CITY OF ALBUQUERQUE

Re: ABB Expansion
6625 Bluewater Road
Traffic Impact Study
HT#K10D011
Engineer Seal date 2/1/2024

Review of the ABB Expansion Traffic Impact Study dated February 2024, received February 1, 2024 has been completed and approved by the City's Planning Transportation Development section. The TIS is approved with the following conditions:

FIGURE 11
ABB EXPANSION
ALBUQUERQUE, NEW MEXICO
RECOMMENDED GEOMETRY AND CONTROL

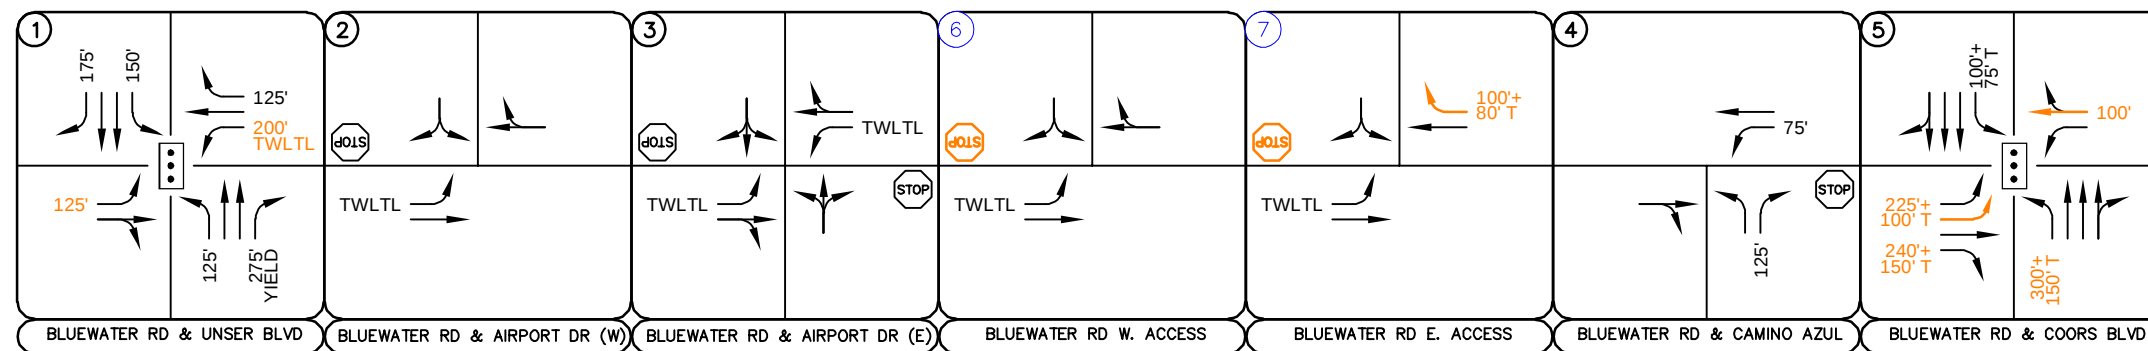
1. All requirements and infrastructure improvements directed by the NMDOT shall be complied with.
2. The East Access on Bluewater Rd. shall be reconstructed to include a right-turn lane.
3. The west leg of the Bluewater Rd./Coors Blvd. intersection shall be reconfigured as outlined in the study by replacing the pavement striping, words and symbols, including the crosswalk and all required signing.
4. The westbound left-turn lane on Bluewater Rd. approaching Unser Blvd. shall be restriped to increase the turn lane length.
